Project Title: The Carlisle Condominiums Building Permit #: \_\_\_\_\_ City Drainage #: K17 / D069

**Re: The Carlisle Condominiums  
Grading and Drainage Plan  
Engineers stamp date 9-16-15 (K17 / D69)**

**Re: The Carlisle  
SW Corner of Carlisle/Central  
Grading and Drainage Plan  
Engineer's Stamp dated: 9/1/2015 (K17D69)**

## GRADING &amp; DRAINAGE PLAN

CONCEPTUAL GRADING & DRAINAGE PLAN

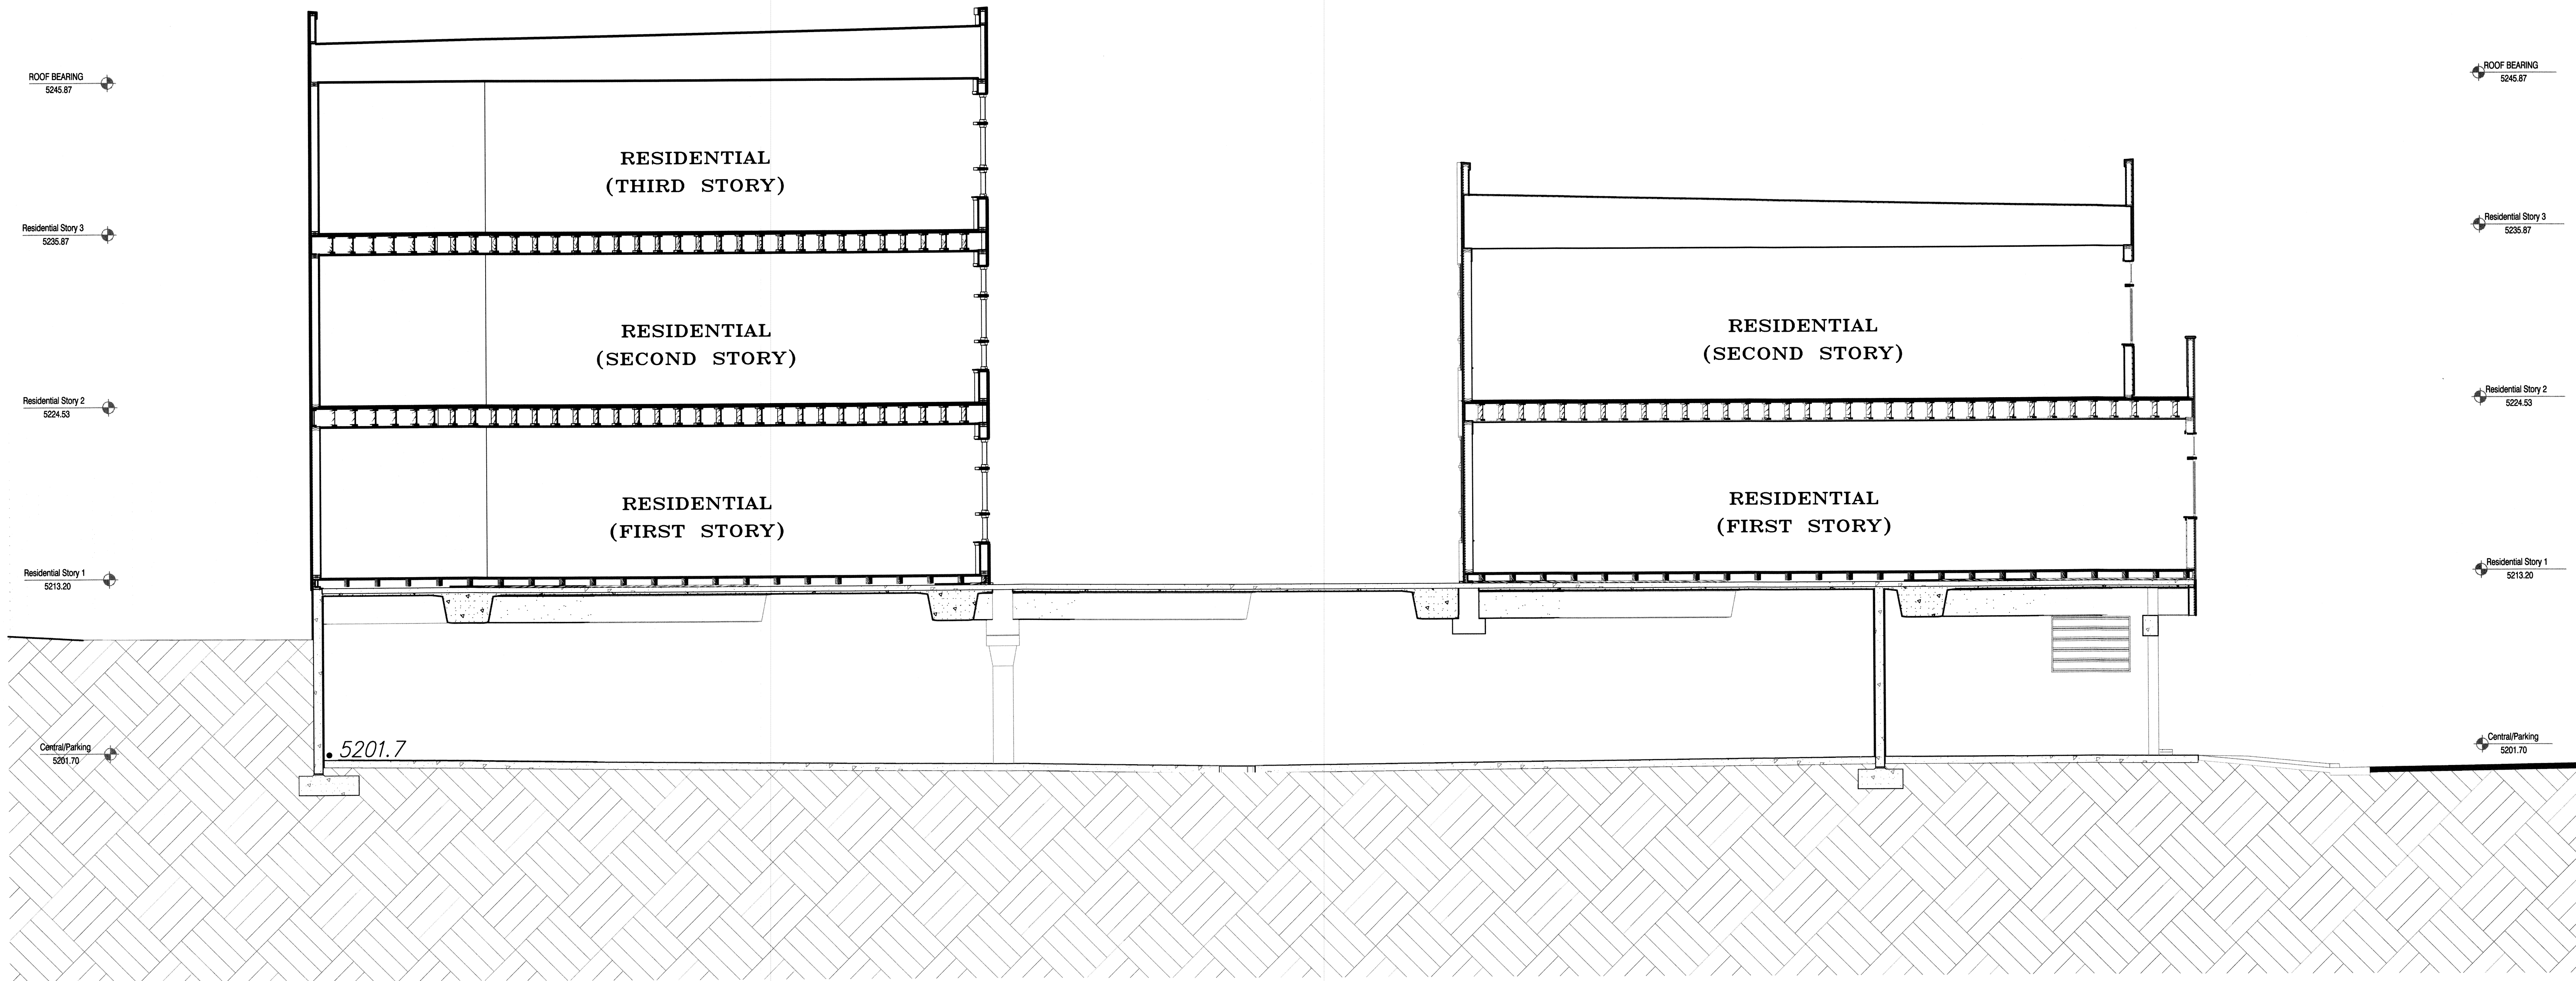
- Provide the type of surface in the storage tank (Impervious concrete, bitumen).
- Provide what the existing drives will be replaced with (Walkway, landscape). ✓
- Provide what is in the areas to the north and west of the building.
- Provide a keyed note for the sidewalk culvert mentioning the city spec. ✓

1. The storage tank will be concrete and lined with XYPEX Concentrate. The products' specification is attached.
2. More detail has been provided along the concrete areas adjacent to Carlisle Blvd. and Central Ave.
3. More detail provided.
4. City spec. for sidewalk culvert has been added to the plan.
